**RESPONSE TO OBSERVATIONS
(ACP-323579-25)**

Ballinla Wind Farm

Ballinla Wind Farm Ltd.

January 2026

Figure 2-6: Site Entrances off L5010

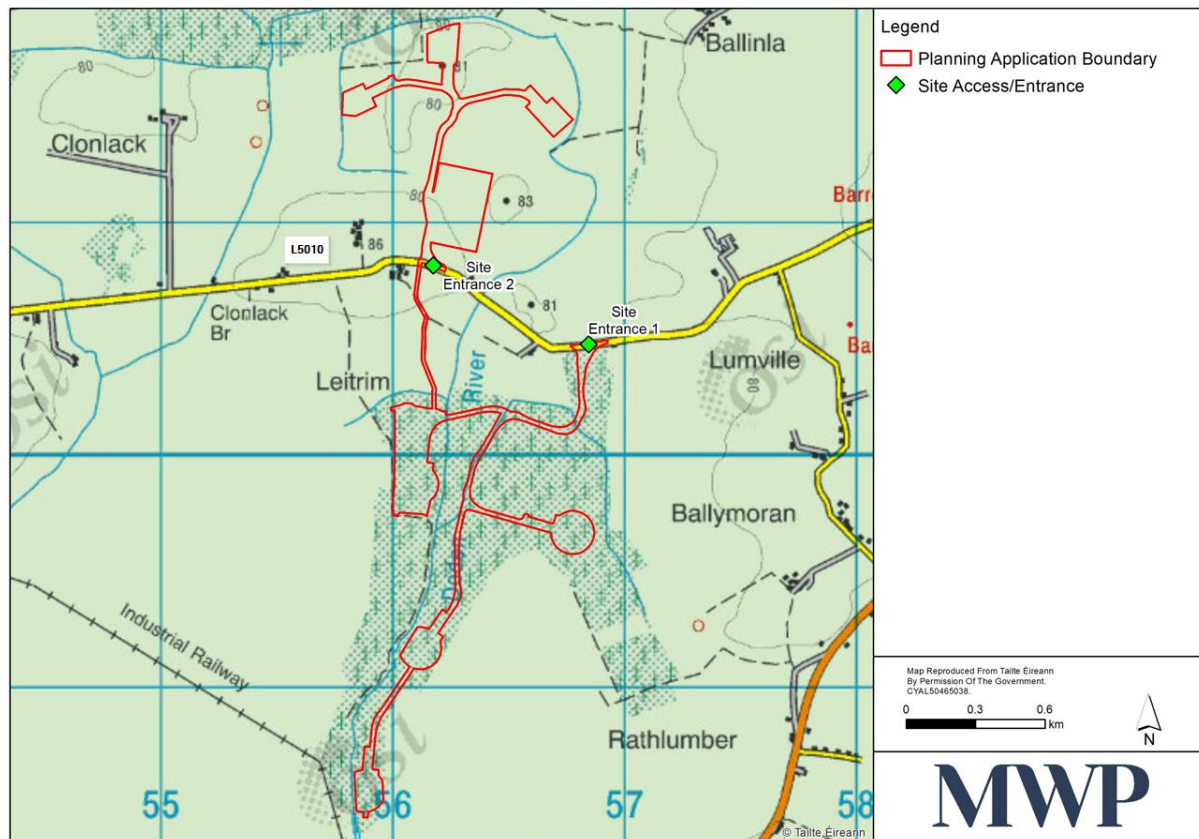
Ref	OCC RFI Request	OCC Proposed Condition Reference
a)	The applicant shall submit details on proposals for the existing public road at the proposed site entrances on the L5010 including proposals for strengthening the road fabric at the entrances, to resist damage likely to be caused by HGV's entering and existing the site during the construction period. These details should include proposed road build up/specification, which shall comply with TII Specifications for Road Works Series 900 (latest edition) and details of longitudinal & cross sections.

b)	The Applicant shall submit drawings with details of surface water measures at the proposed site entrances including roadside drainage and details of gully and soakaway locations. The drawings shall also detail/show any proposed line marking and signage at/near the site entrances.	Proposed Condition 1 Refer to Section 3.1.3.

Proposed Condition Reference	Proposed Condition	Response
1	Prior to commencement, the applicant shall submit details to OCC/Edenderry MD regarding: (a) Road strengthening at entrances; (b) Surface water measures at entrances; (c) Line marking and signage; (d) Measures to mitigate deposition/spillage; (e) Wheel wash details; (f) Passing bay details; (g) Temporary turning head details at Ballyfore R402/L5006 junction.	The CEMP included in the application commits to road protection, drainage controls, wheel wash facilities, traffic management and construction phase mitigation. All mitigation measures included within the EIAR and CEMP shall be implemented in full. An updated CEMP containing site specific details of all on-site construction works, post-construction reinstatement, drainage, mitigation, and monitoring measures, together with details of their timetabling, shall be submitted to, and agreed in writing with the local authority prior to commencement of development.

Figure 2-8: Temporary Construction Compound

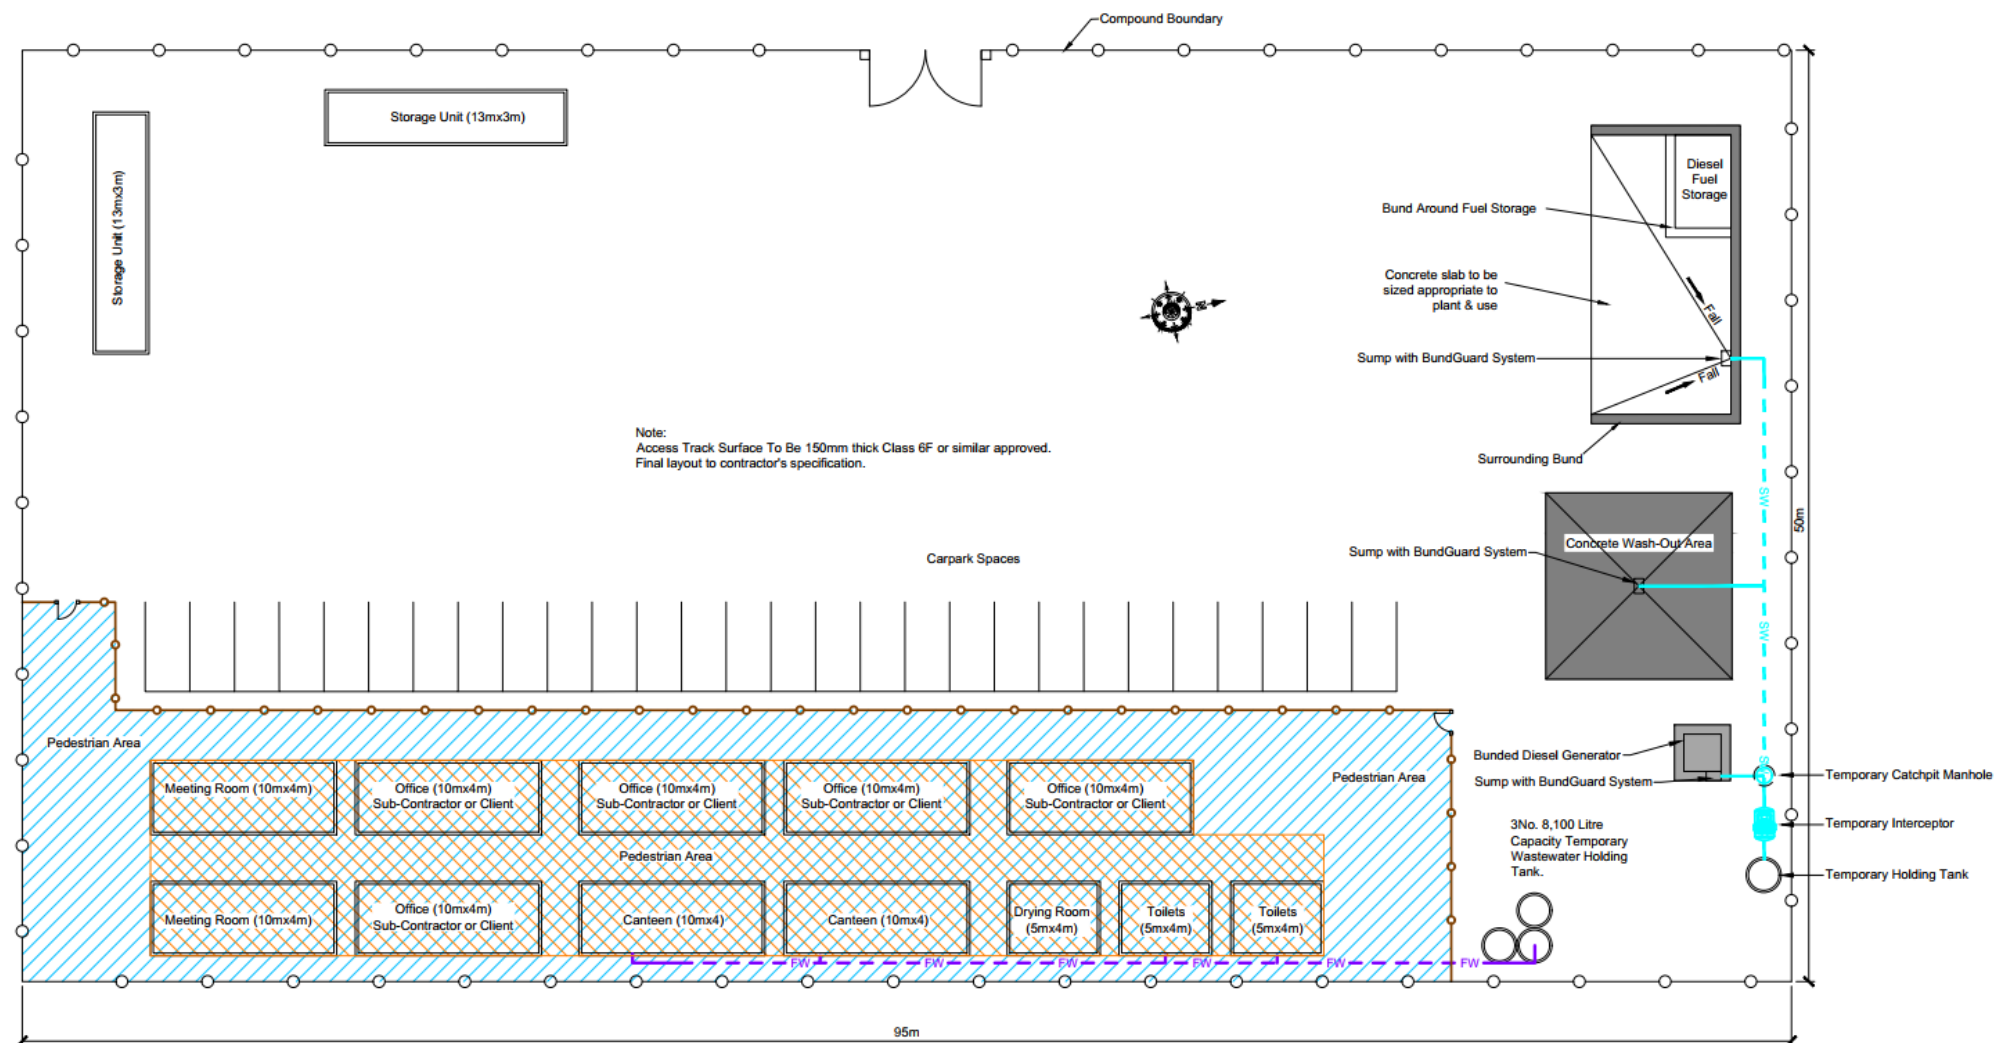
Proposed Condition Reference	Proposed Condition	Response
8	Submit a Construction Management Plan (CMP) covering compound layout, phasing, traffic, noise, dust, waste, refuelling, surface water, etc.	A CEMP has been submitted as part of the planning application in addition to a construction compound layout (23882-MWP-00-00-DR-C-5411). The CEMP includes details of compound layout construction phasing, traffic management, noise and dust control, waste handling, refuelling procedures and other site operations. This CEMP will be updated and finalised prior to commencement of development and submitted for the written agreement of the Planning Authority. The development will thereafter be carried out in full accordance with the agreed CEMP.
9	Any changes to material sources or haul routes must be notified to OCC.	The applicant accepts this condition and will notify OCC of any changes to material sources or haul routes in advance.

Figure 2-11: Wind Farm developments within 25km of Proposed Development

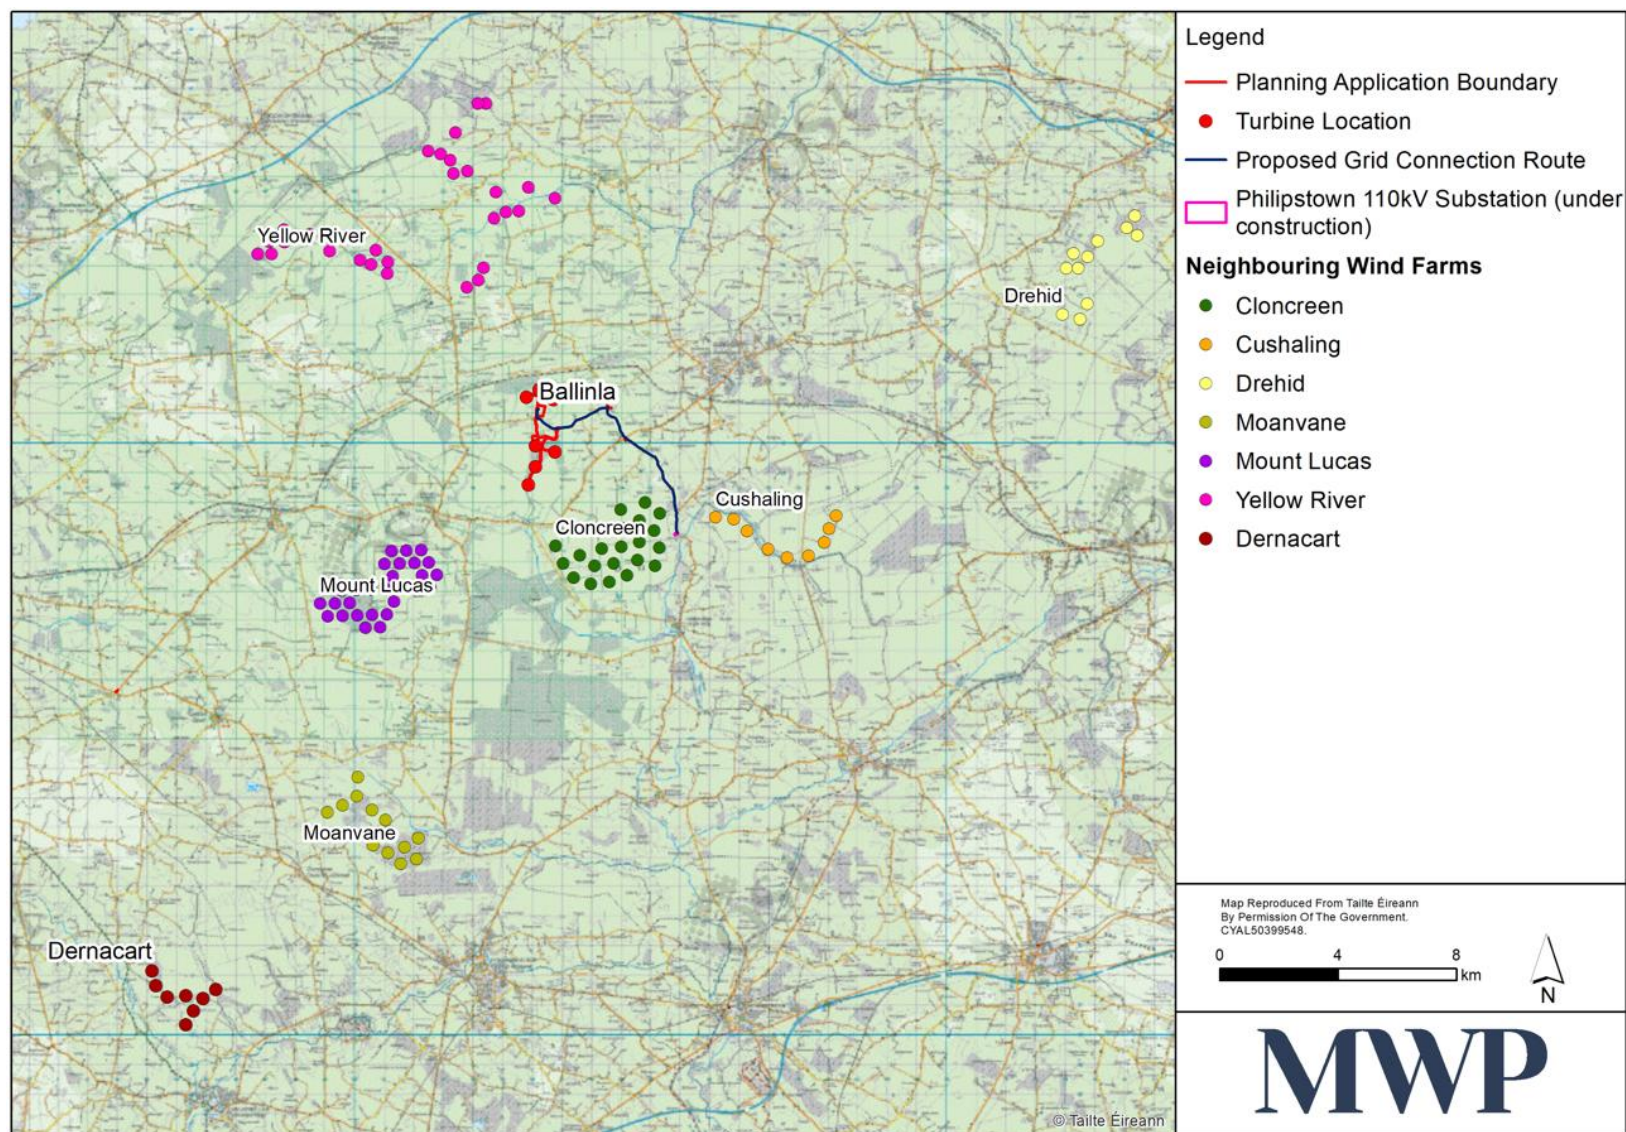
Item No.	Comments/Queries	Response
		which demonstrate that the Proposed Development will operate within the guideline thresholds.
7	Pg 36 A map showing all dwellings (existing, granted permission and under construction) within 2 kilometres of the proposed turbine locations should be provided as part of this chapter.	A figure showing the locations of residential houses within 10 times the rotor diameter (1.62km) is provided in Figure 16-2, Chapter 16 Shadow Flicker. A comprehensive check was undertaken to ensure that there were no granted planning or dwellings under construction missing from this area within the assessment process.
8	Pg 36 A map showing all permitted and under construction energy developments within 15km of the subject site should be provided as part of this chapter.	Figure 2-11 is provided in Chapter 2 Project Description of the EIA showing all proposed, consented and existing wind farm developments within a 25km radius.

Figure 15-4: Haul Routes

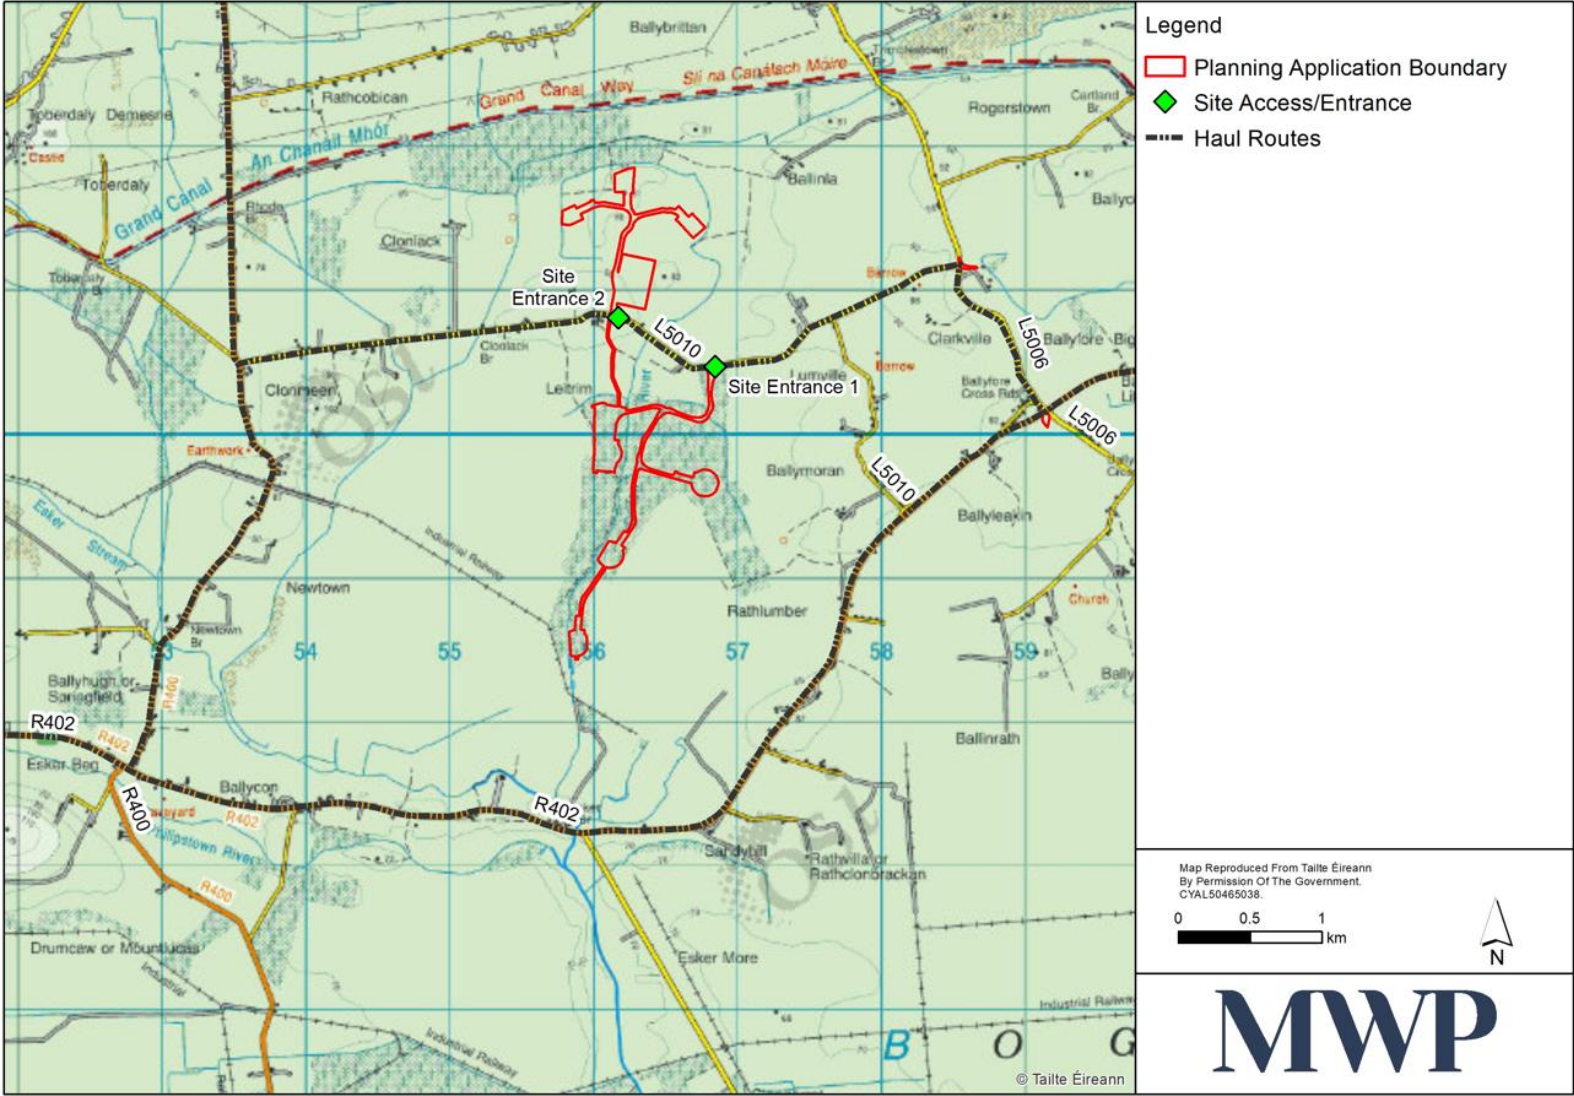
6	No construction delivery vehicles shall access the site via the northern L5006 and Trimblestown Bridge.	The applicant accepts this condition. As confirmed in the TMP and TDR Assessment submitted with the planning application, the designated haul routes for construction traffic and abnormal loads do not include the northern section of the L5006 or the Trimblestown Bridge. No construction delivery vehicles will access the site via this section of the road network, and all construction traffic will be routed in accordance with the agreed haul routes set out in the application documentation.
7	Visibility splays at all entrances to comply with DMS-097/098; hedges to be trimmed; wheel wash to be used.	<p>The proposed site entrances, including the required visibility splays, are detailed in Drawing No. 23882-MWP-00-00-DR-C-5032, which accompanies the application. Any necessary hedge trimming to maintain compliance with DMS-097/098 will be undertaken prior to commencement of construction.</p> <p>In addition, the CEMP commits to the provision and operation of a wheel wash facility at each site entrance, ensuring that mud and debris are not deposited on the public road network. The development will be carried out in accordance with these submitted plans and commitments.</p>
